6 November 2013

Name: PAT MAYNARD
Address: 53 CALDER RD
DARLINGTON
2008

**Modification Request for the University of Sydney Abercrombie Precinct
Redevelopment: Application Number: MP07_0158 MOD 3**

Title
Scale
Date
Number
0 2 4
10 20m
Ground Floor Plan
MARK UP SET
1:200@A1
11.10.13
4001_DA02-D
© copyright nettleton tribe partnership pty ltd

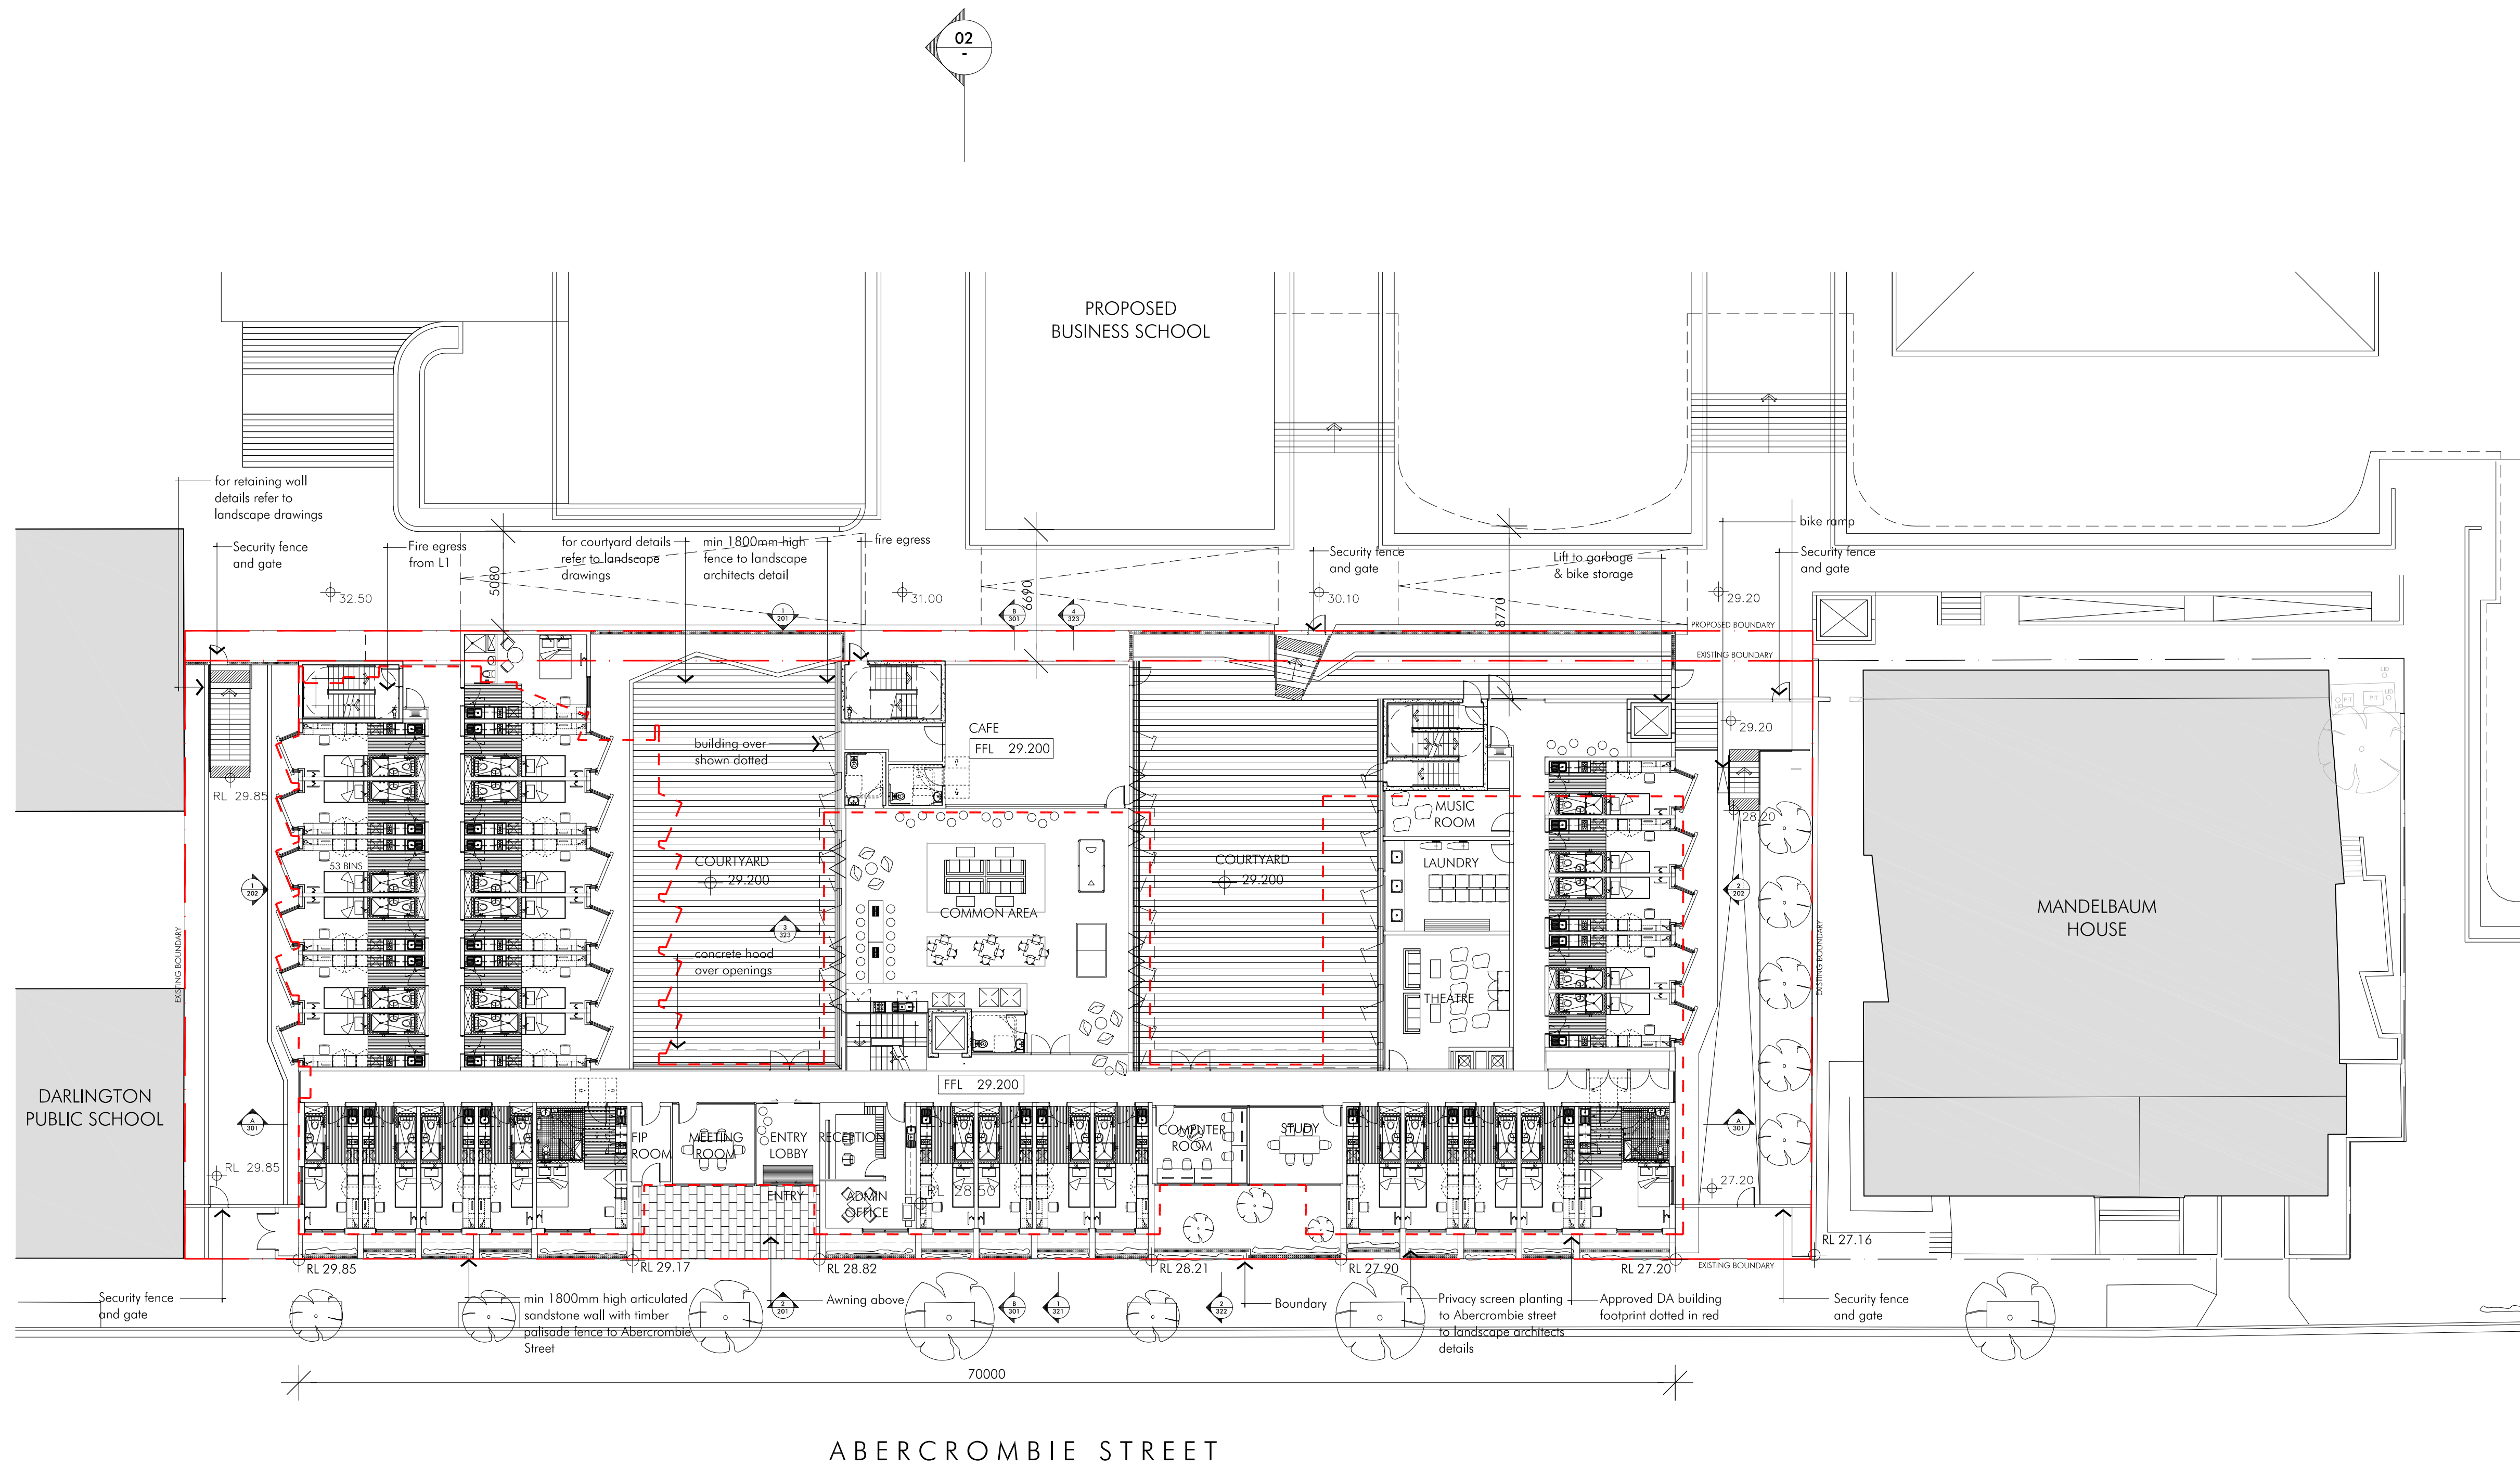
- The front of the Student Accommodation building should be built 2 metres back from the Abercrombie Street boundary. It should be set back from this boundary so that it is in line with Mandelbaum House as it was originally planned and presented to the community. The footprint of the buildings currently on the site, The Shepherd Centre and Boundary Lane Children's Centre, were built approximately 2 metres back from the Abercrombie Street boundary and align with Mandelbaum house. Therefore, the front footprint of the proposed Student Accommodation building should be the same as those buildings occupying the site at present and not be built up to the Abercrombie street boundary.

- The facade of the proposed Student Accommodation building does not reflect the heritage appearance of the Victorian terraces on Abercrombie Street as Mandelbaum House does. Therefore, it should be set back to allow for extensive vegetation and trees to be planted in front of the building on Abercrombie Street to help preserve the heritage streetscape and improve both the aesthetics and the environment of the street.
